SPR EA1N and EA2 PROJECTS

DEADLINE 9 – COMMENTS ON CAH3 SUBMISSIONS

Interested Party: SASES PINS Refs: 20024106 & 20024110

Date: 15 April 2021 Issue: 1

East Anglia TWO Offshore Wind Farm

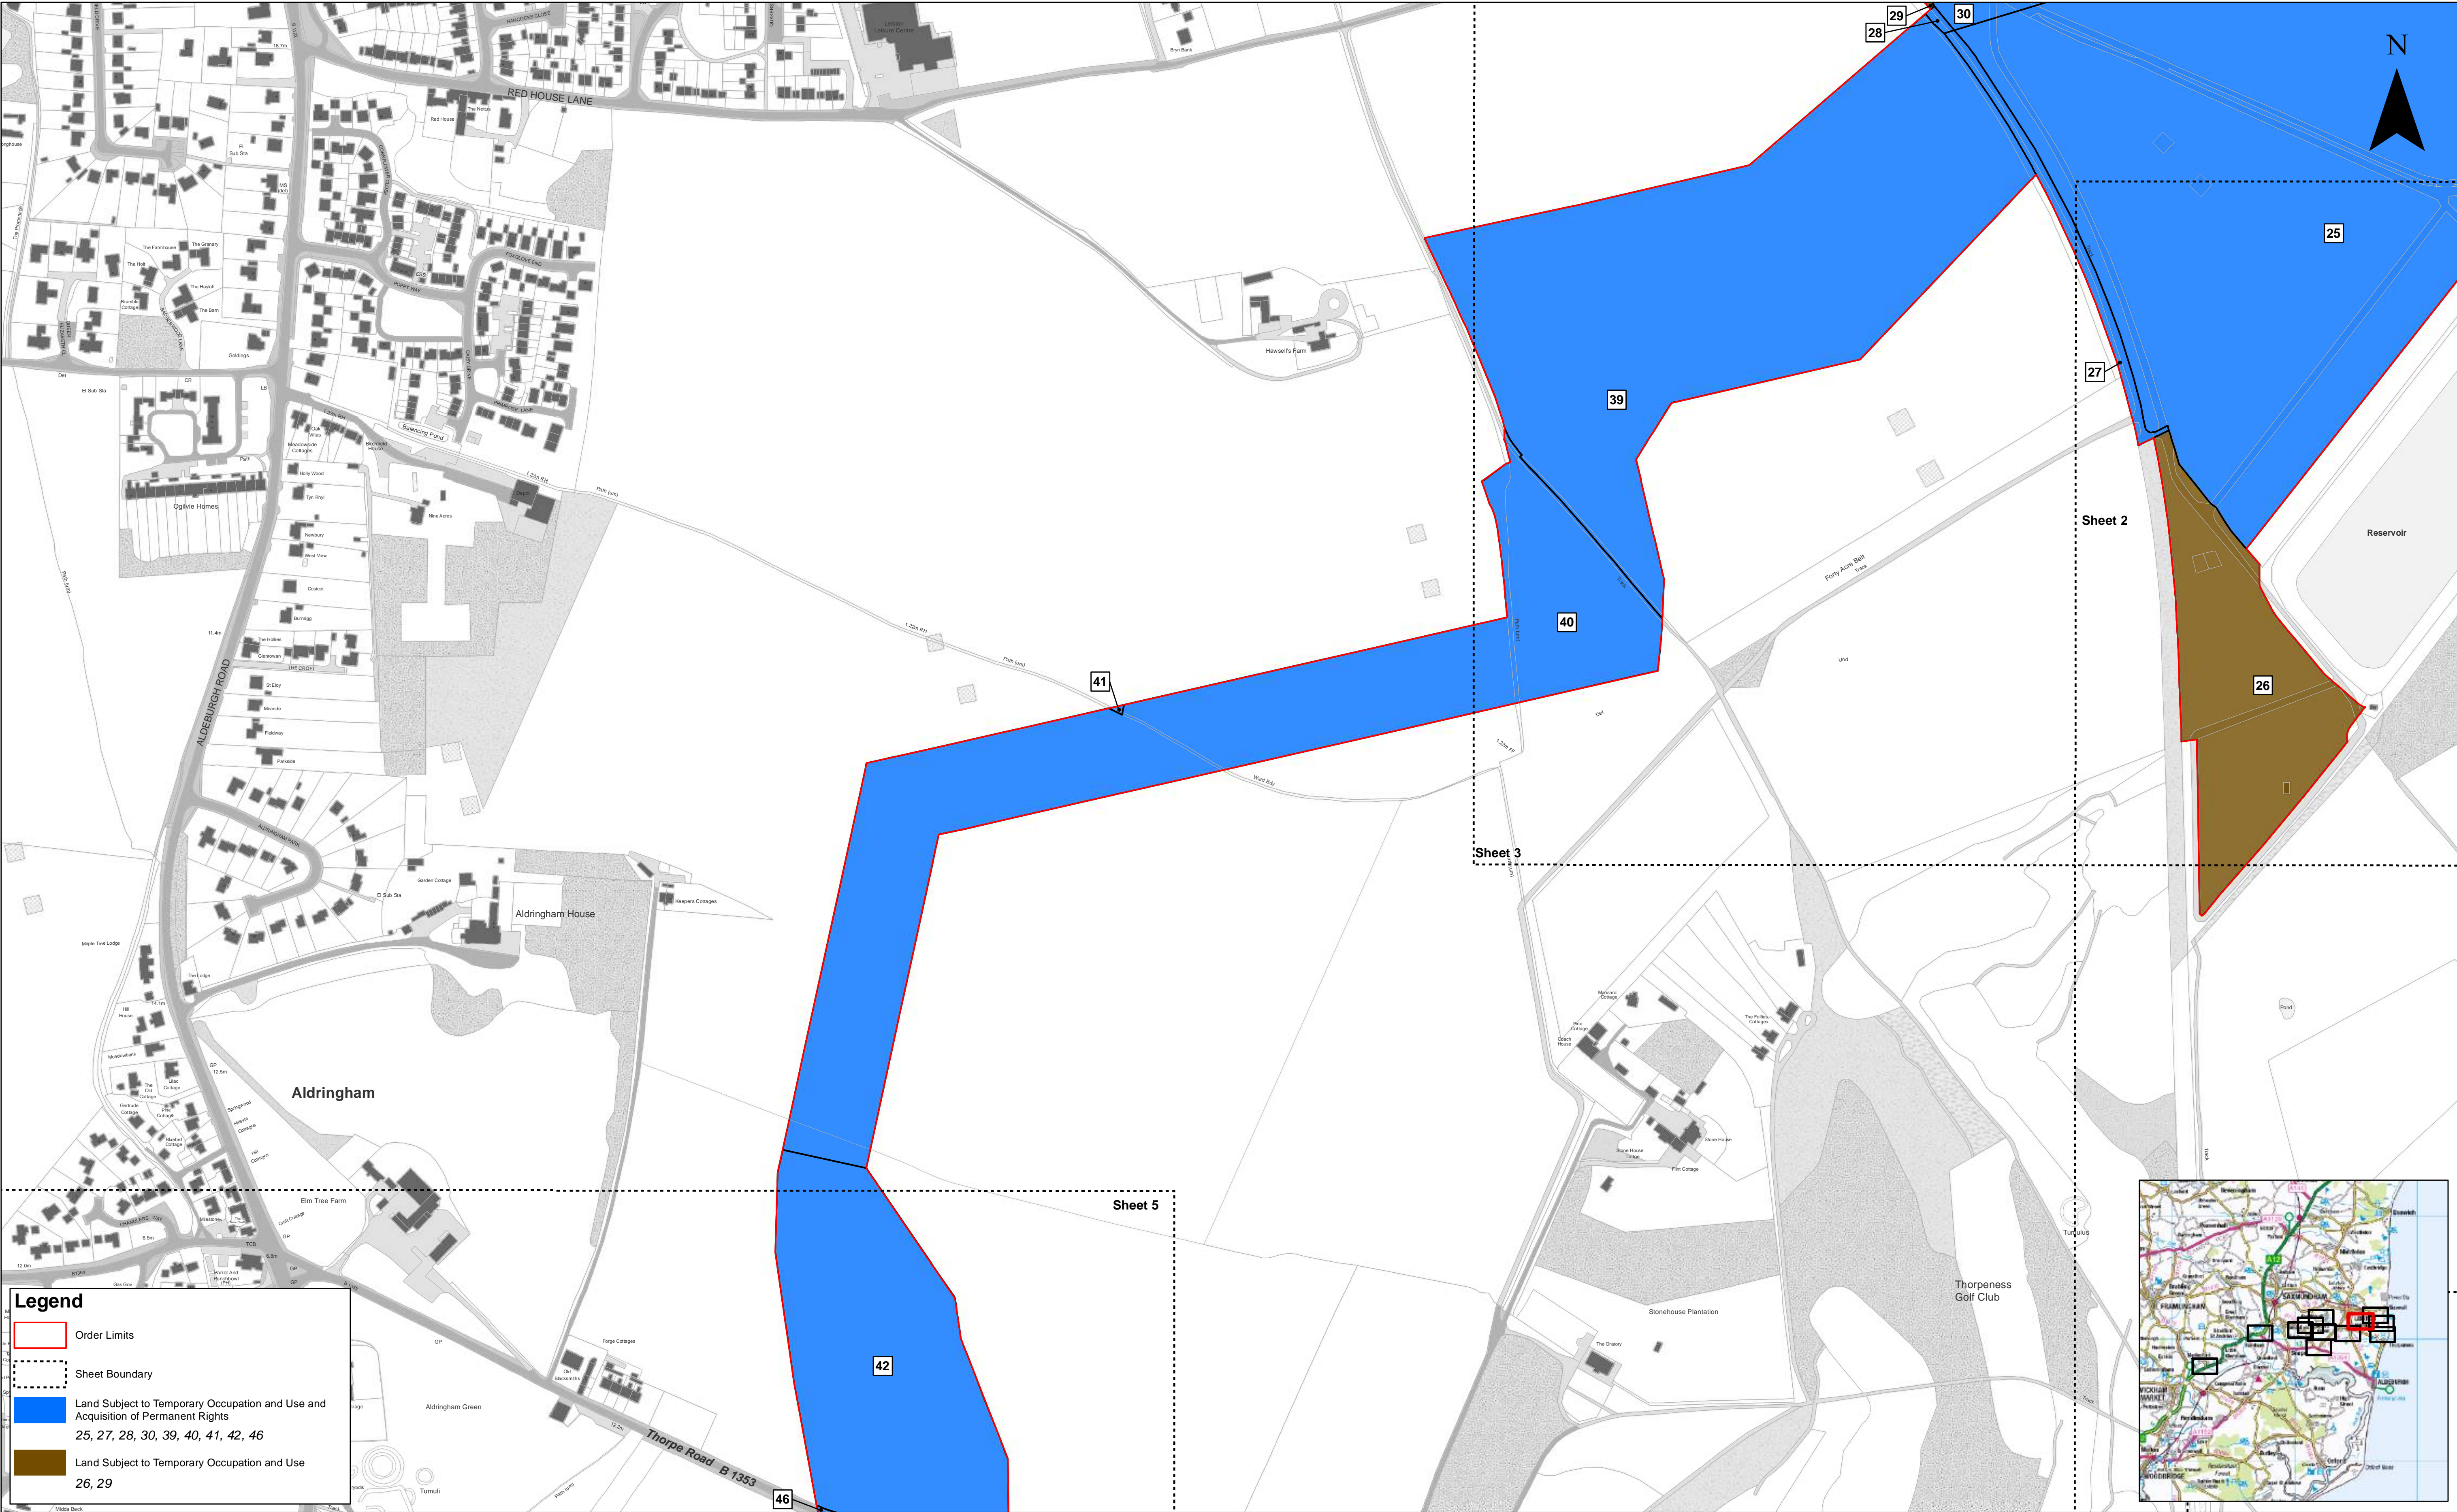
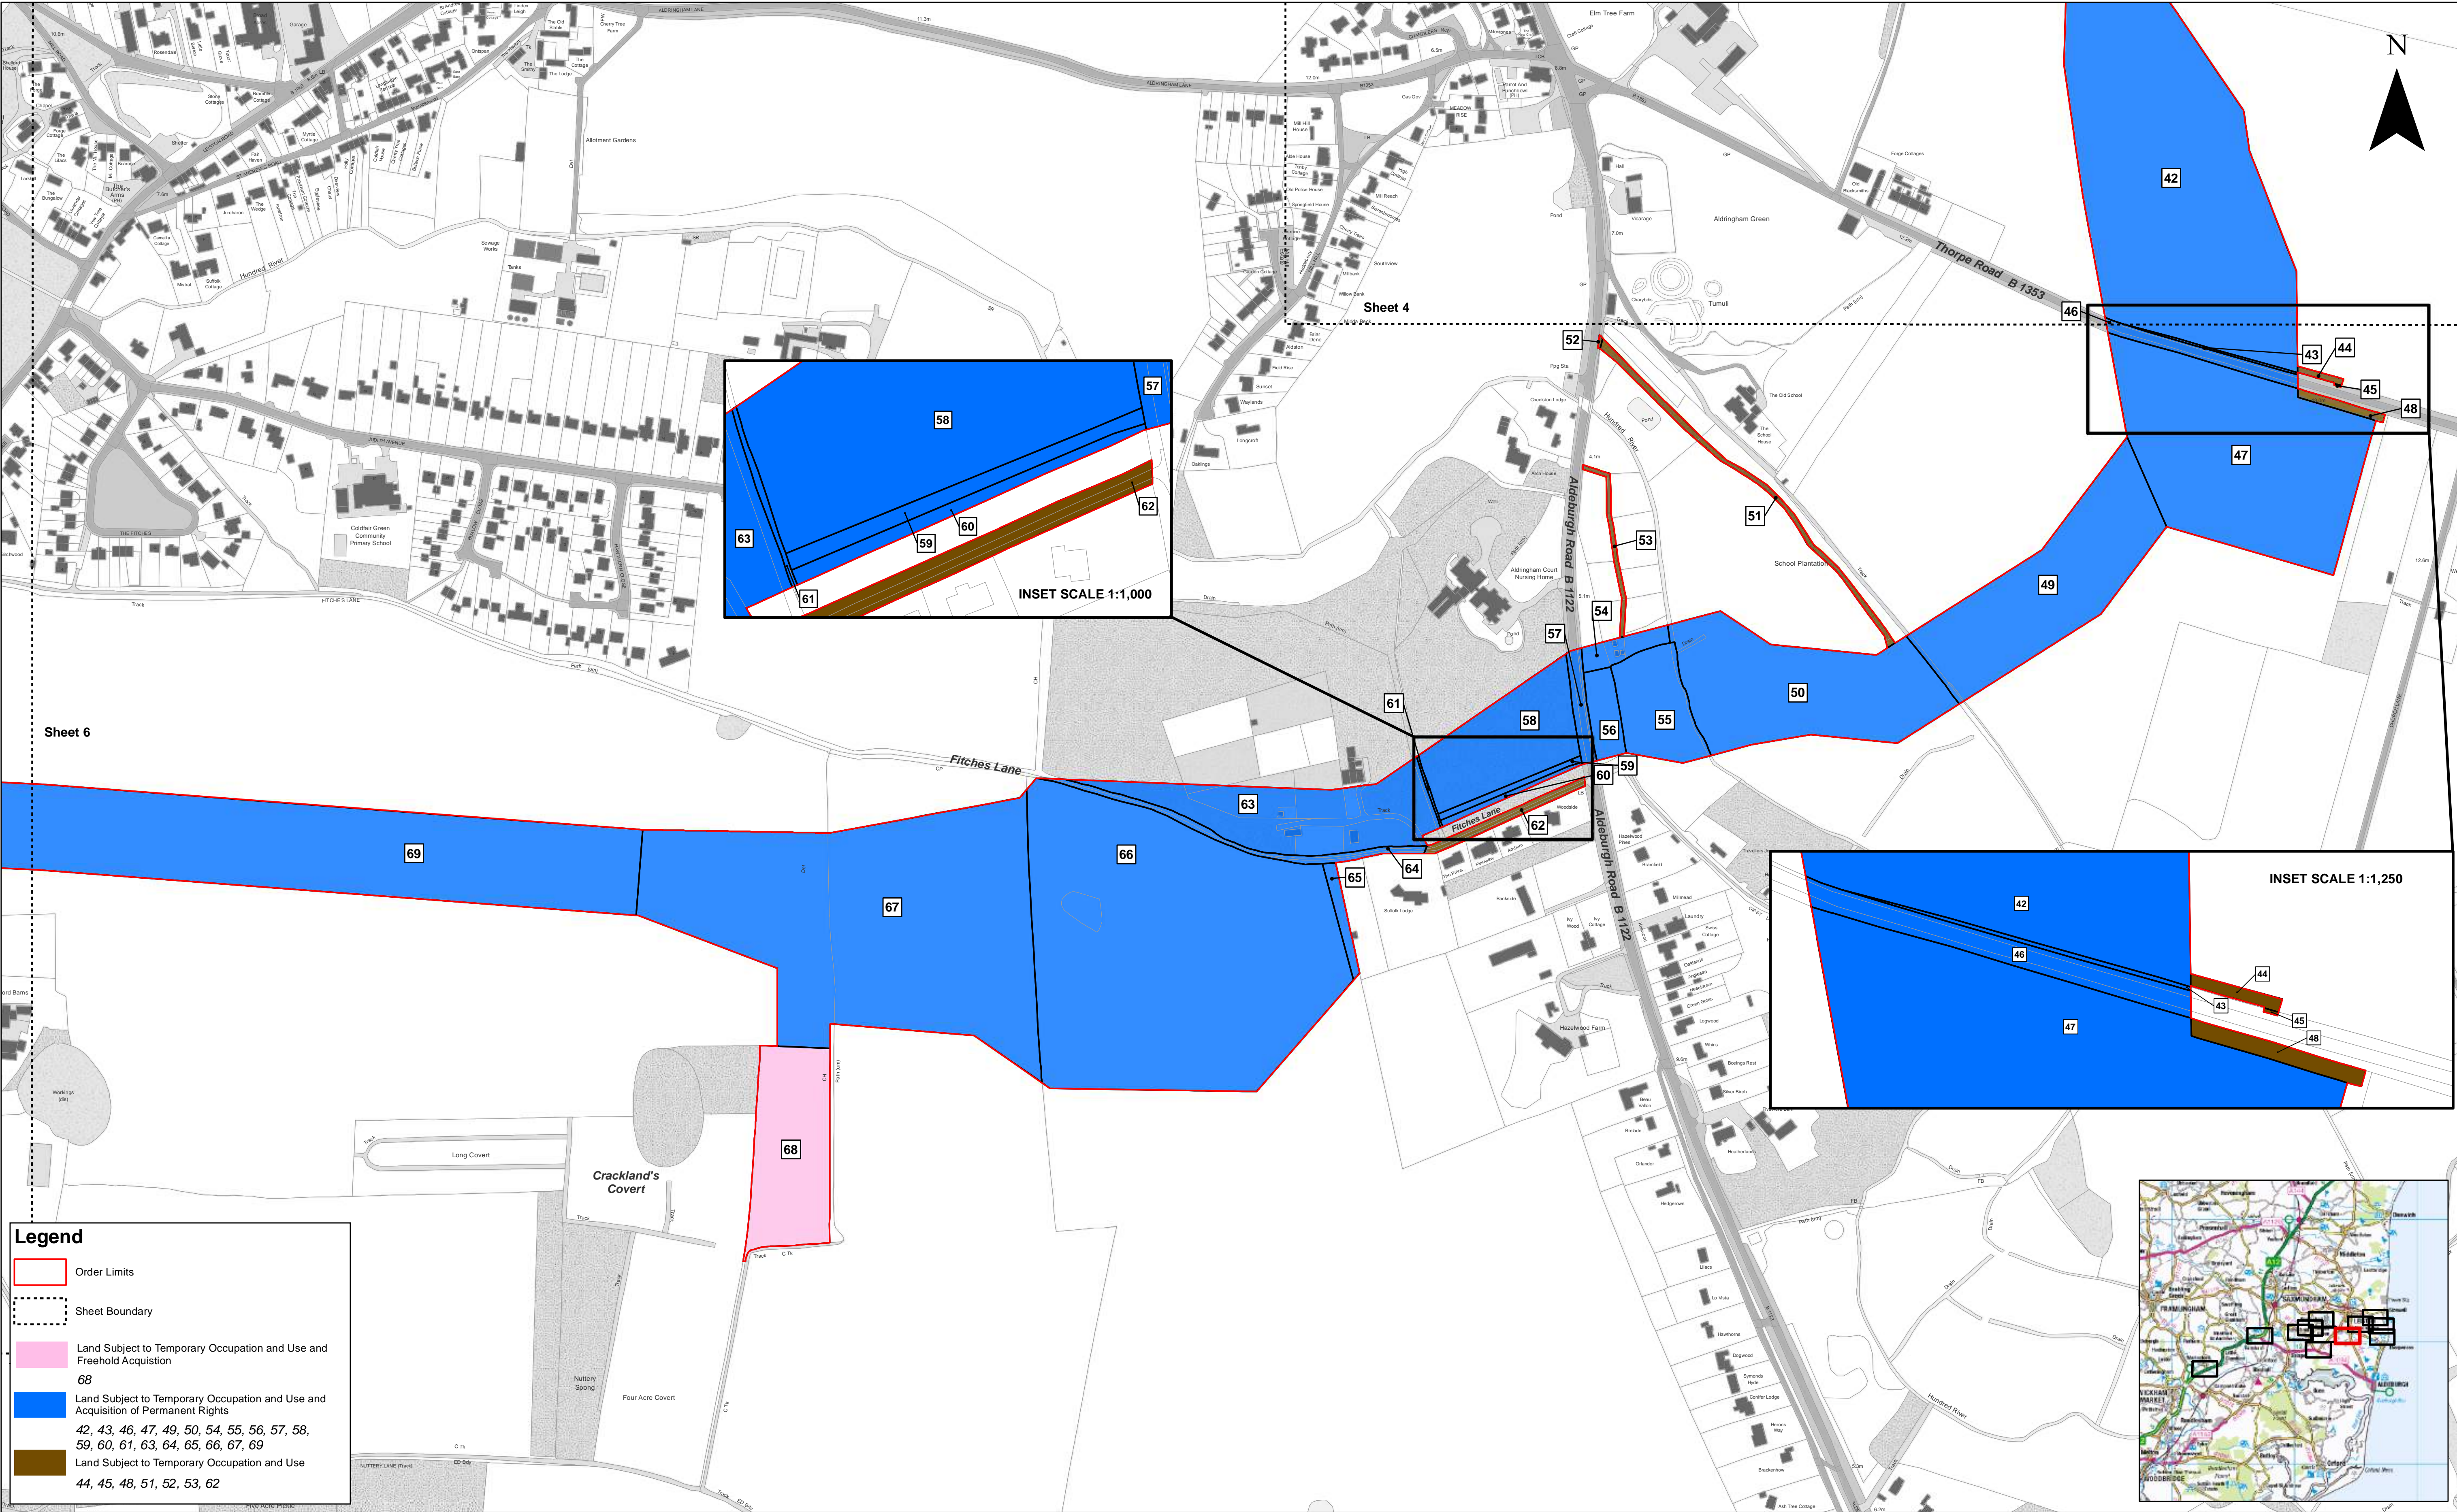
19. However, on examination of EA1N/EA2 Land Plans Rev 04, in conjunction with Suffolk Definitive Maps and Statement of public rights of way and views from Google Earth, only circa 770m of those sections of the 9.2Km cable corridor whose width is less than 75 are adjacent or even close to field boundaries. That immaterial potential saving of short 35m wide strips (at plots 13,15 and 85) cannot justify an excessive land take of 35 metres width over the remainder of the length of the cable corridors.
